Director Infrastructure Projects  
 Department of Planning and Environment  
 Application number - SSI 13\_6136  
 Major Projects Assessment  
 GPO Box 39 Sydney NSW 2001

Re: NorthConnex Application Number: SSI 13\_6136

The submission is submitted by Councillors Ryan Tracey, Raymond Harty OAM and Tony Hay OAM Councillors of the Hills Shire Council and represent a minority report in the form of a submission that differs from the position by way of a resolution adopted by a majority of Councillors at the Council Ordinary meeting held on 9 September 2014.

MOTORWAY OPERATIONS COMPLEX - SOUTHERN VENTILATION FACILITY - SECTIONS
M1-M2-5000-DR-JD-0525

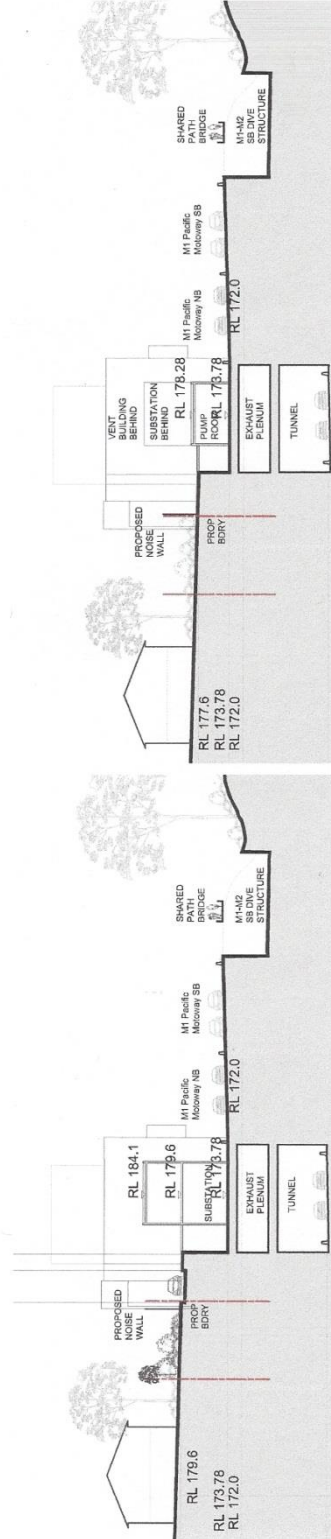
The twin tunnels must be connected to a filtered ventilation stack at the Southern Interchange. Documented evidence must be provided with details describing and demonstrating how the connection will work. Time for public scrutiny must be provided.

The provision of diagrams and detailed description of what ventilation is proposed for the southbound tunnel at the Southern Interchange is completed. (Showing connection of the ventilation stack and the south bound tunnel).
